**WEST SUSSEX COUNTY COUNCIL
INFRASTRUCTURE CONSULTATION**

SUBJECT: BR/3/09/L - Application for Listed Building Consent to erect ornamental railings along the concourse area with a 2.5m swing gate which will remain open whilst station is open

Bognor Regis Railway Station, Station Road, Bognor Regis, West Sussex

PLAN ARRANGEMENT TO PROPOSED FENCE LINE

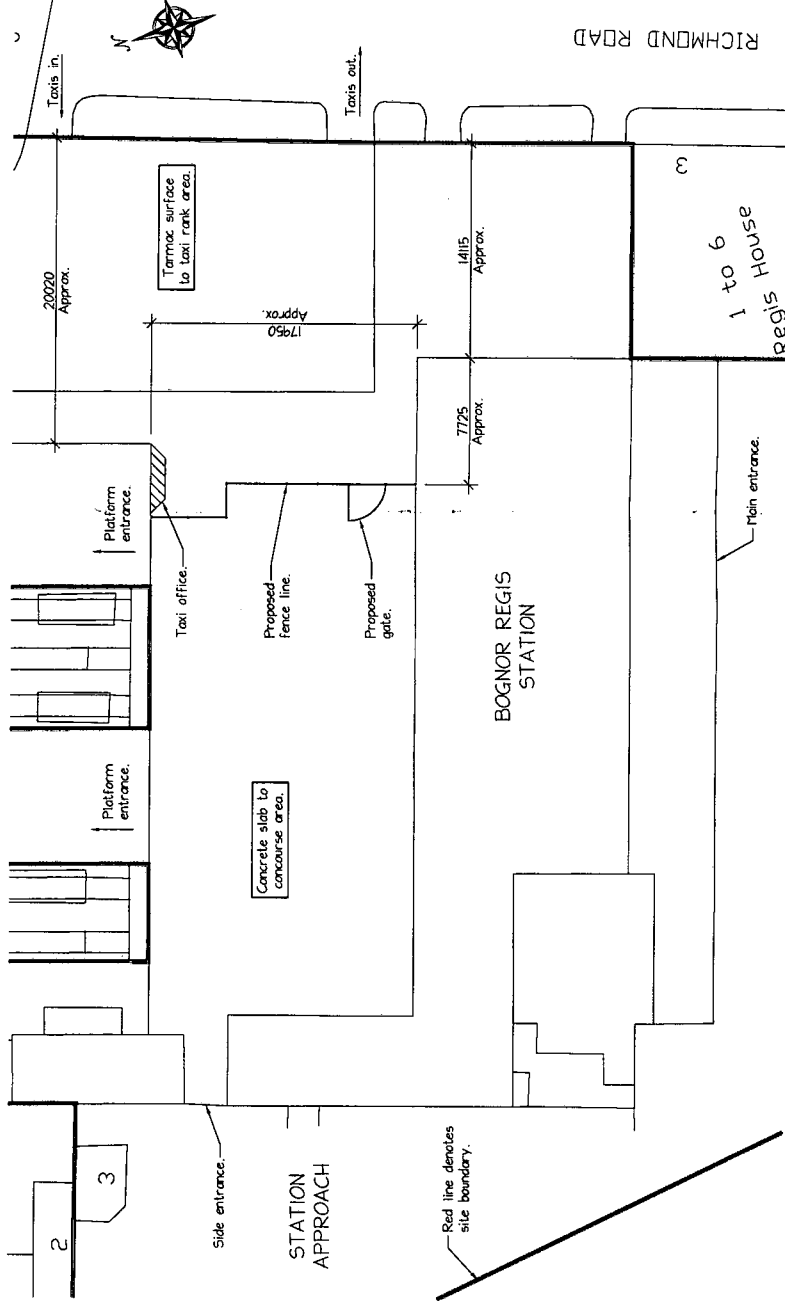
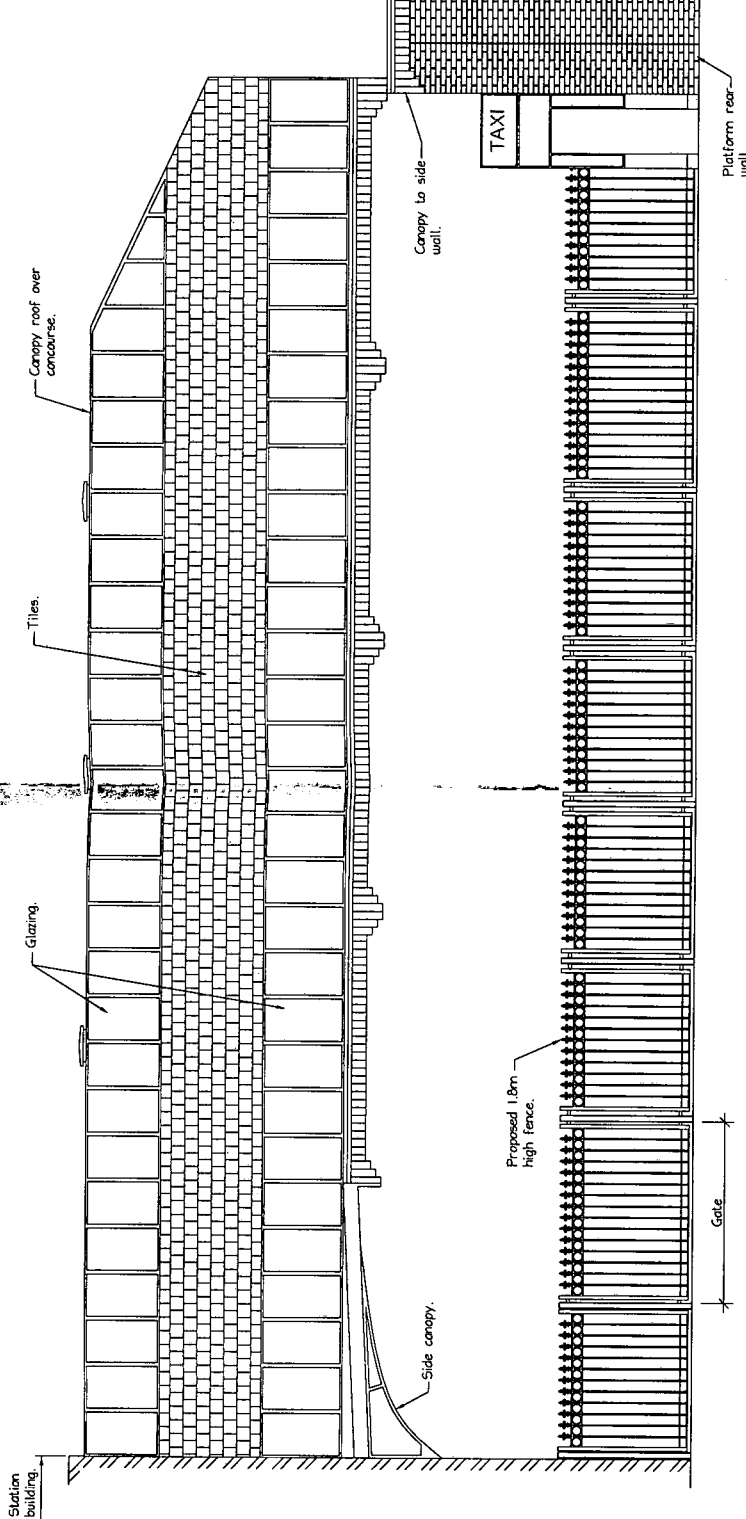
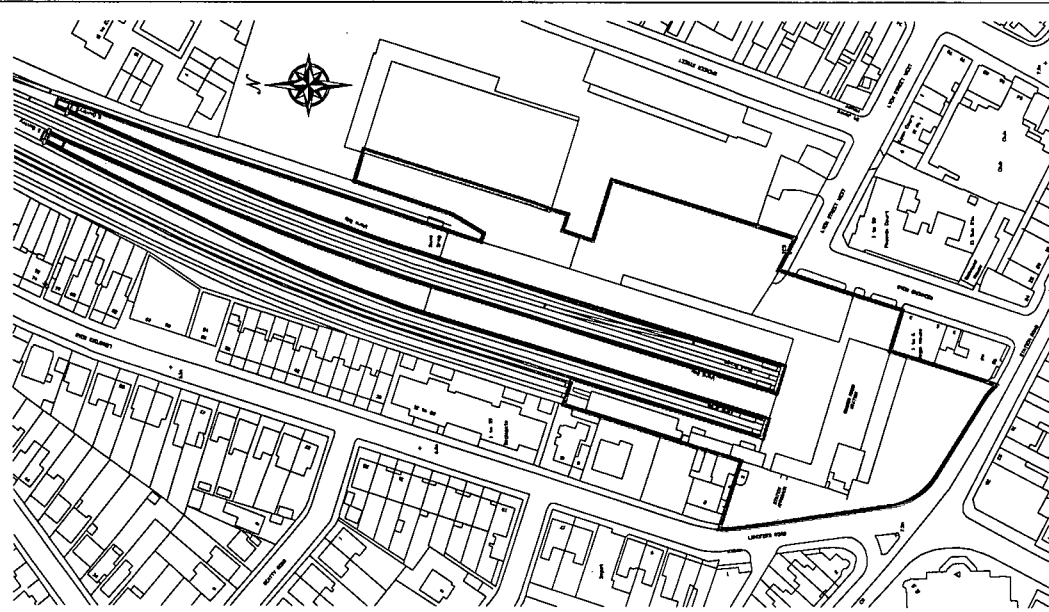
The proposal is for a 2.5 metre swing gate with access onto Station Road. The proposed gates must open away from the highway. Providing this can be achieved the gates location is unlikely to increase the amount of traffic in the area and detrimentally affect the highway. The most recently available verified accident records reveal there have been no personal injury accidents in the vicinity where the gate is proposed, indicating a low risk of highway safety issues with this proposal.

Any gates provided at the new site vehicular access shall open away from the highway and be set back a minimum of 5 metres from the nearside carriageway edge of the adjoining highway.
